**KIRKLEES METROPOLITAN COUNCIL
INVESTMENT & REGENERATION SERVICE**

DELEGATED DECISION TO DETERMINE PLANNING APPLICATIONS

Reference No: 2018/62/94103/W
Site Address: 81, Sunny Heys Road, Meltham, Holmfirth, HD9 5PB
Description: Erection of two storey side extension
Recommending Officer: Laura Yeadon

DECISION – conditional full permission

Proposed South West Elevation

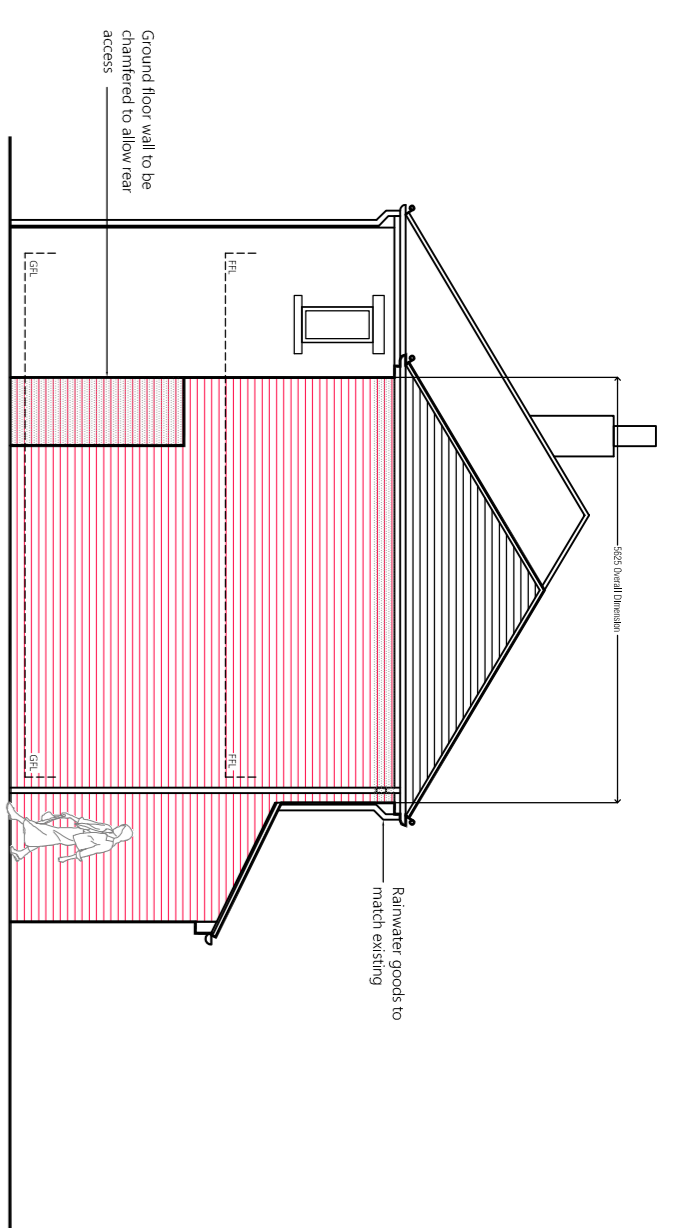
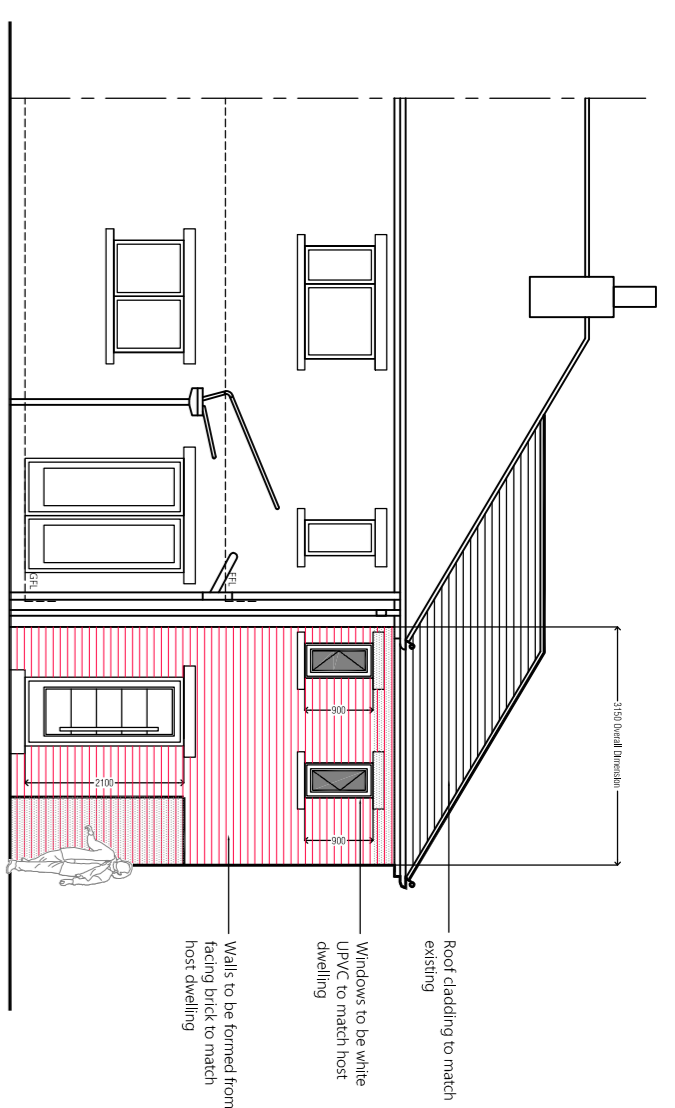
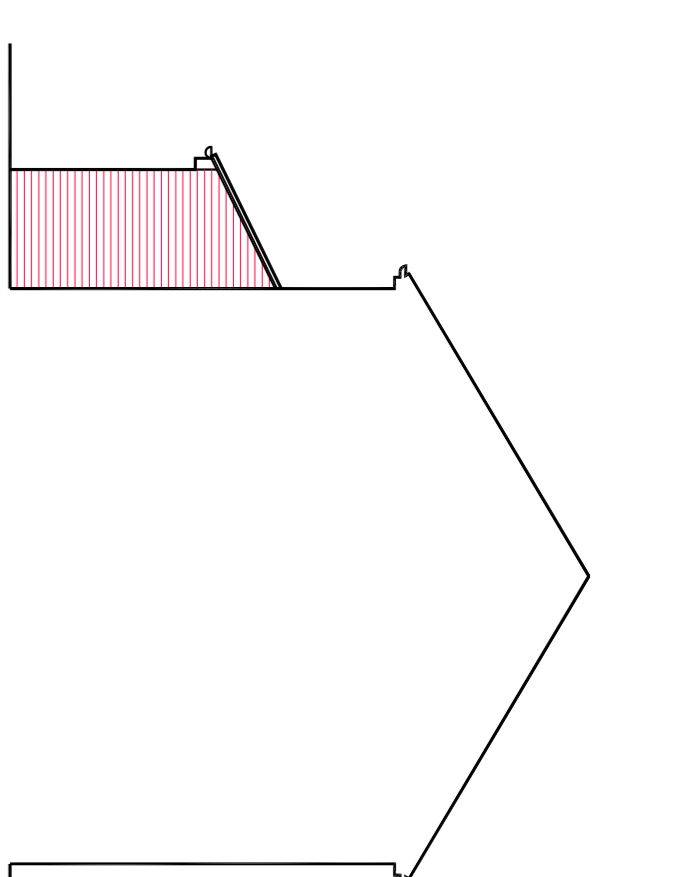
The design of the extension is such that the eaves height would match the existing and the ridge of the property would be set down from the existing. Whilst the extension would not be set back from the front elevation, due to being set in from the ridge line and set in from the rear elevation, the extension would be subservient. The adjacent property is set at right angles to the application site and therefore, no terracing effect would occur should the adjacent property also extend. In terms of the fenestration details, a garage

door opening is proposed within the ground floor of the front elevation with one first floor window above and within the rear elevation, two small first floor openings are proposed alongside a ground floor. No openings are proposed within the side elevation. The proposed openings are considered to be acceptable.

PROPOSED GROUND FLOOR LAYOUT
81 SUNNY HEYS, MELTHAM, HD9 5PB

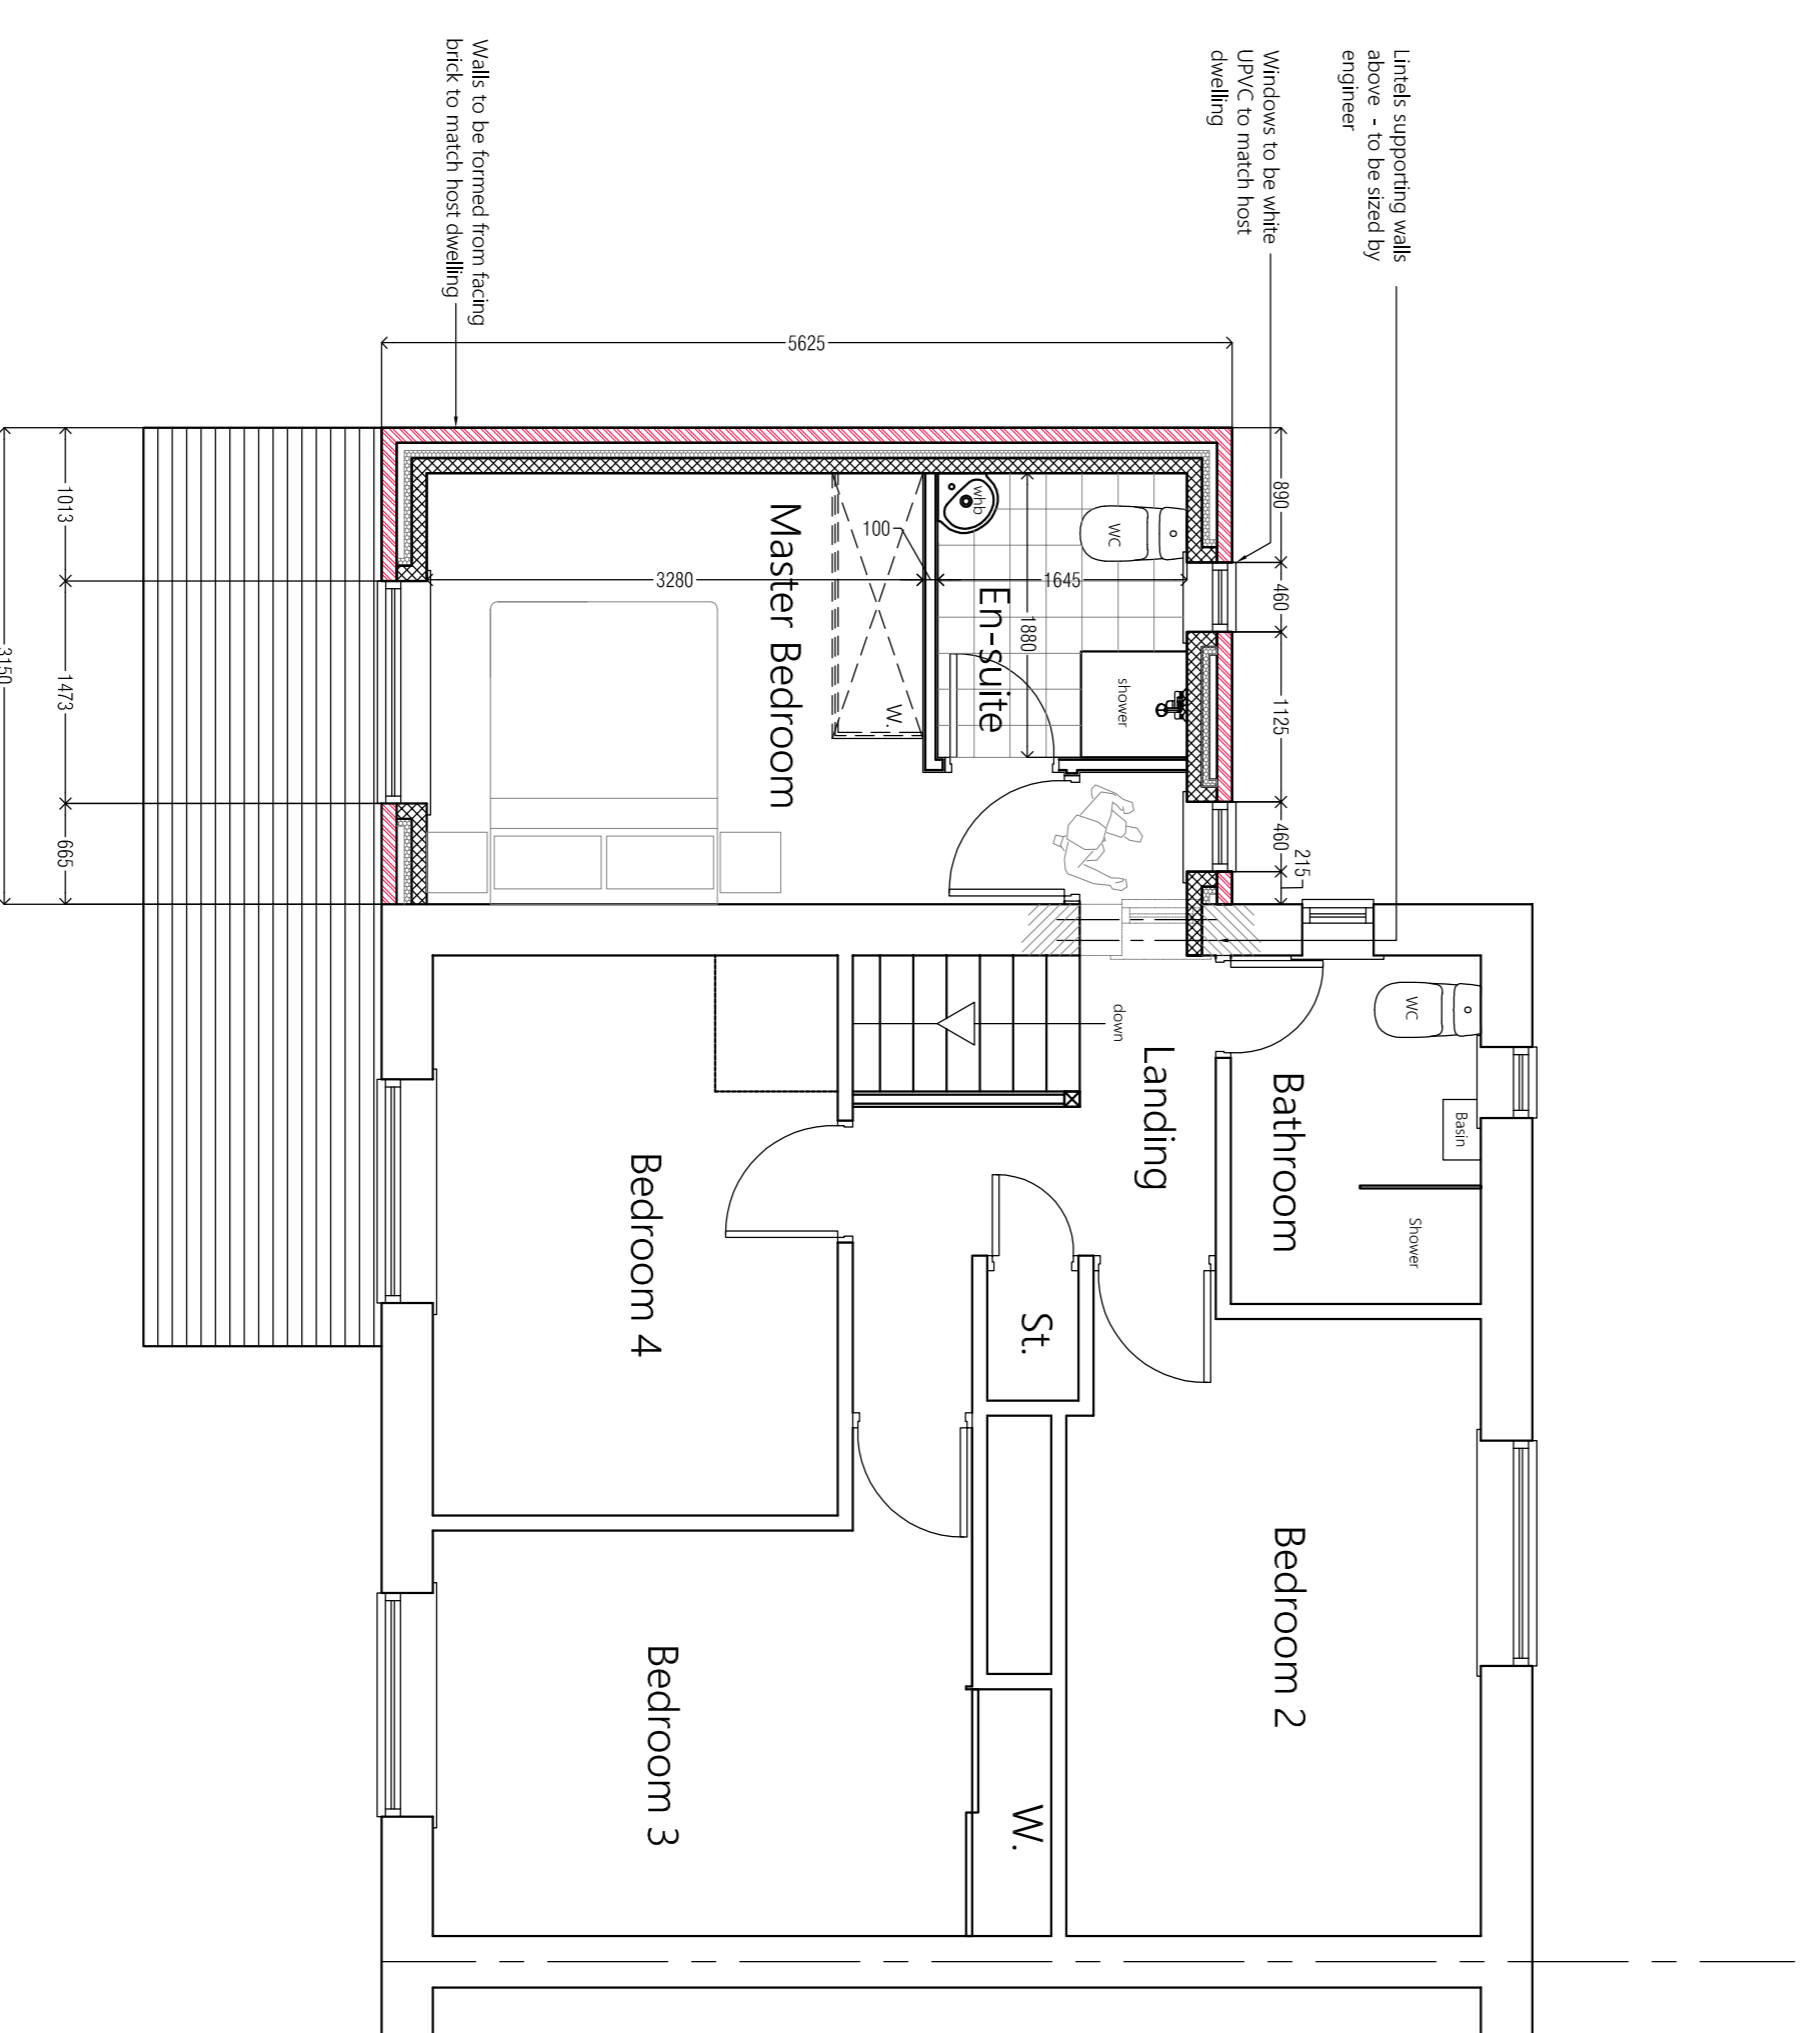
A location plan has been submitted as well as a ground floor layout which demonstrates that some amenity space to the side and front of the property would be retained and there are no proposed works to the rear of the property. It is therefore considered that the scheme would result in an overdevelopment of the site.

The submitted details indicate that the ground floor of the extension would be a garage and also that a hardstanding area would be created to the front of the building by using permeable paving setts. The garage falls slightly short of the requirements of Manual for Streets in terms of the garage sizes however there is a driveway to the front of the proposed garage and also alternative

off-street parking proposed. It is therefore not considered that there would have a detrimental impact on highway safety or parking provision as a result of the scheme. This is subject to the imposition of a condition to ensure that the new areas of hardsurface are paved in accordance with DCLG guidance 'permeable surfacing of front gardens'. This would also avoid an increase in flood risk through use of inappropriate impermeable surfacing.

4. The development shall not be brought into use until all areas indicated to be used for parking on the approved plan have been laid out with a hardened and drained surface in accordance with the Communities and Local Government; and Environment Agency's 'Guidance on the permeable surfacing of front gardens (parking areas)' published 13th May 2009 (ISBN 9781409804864) as amended or any successor guidance. Notwithstanding the provisions of the Town and Country Planning (General Permitted Development) (England) Order 2015 as amended (or any Order revoking or re-enacting that Order) these areas shall be so retained, free of obstructions and available for access/parking thereafter.
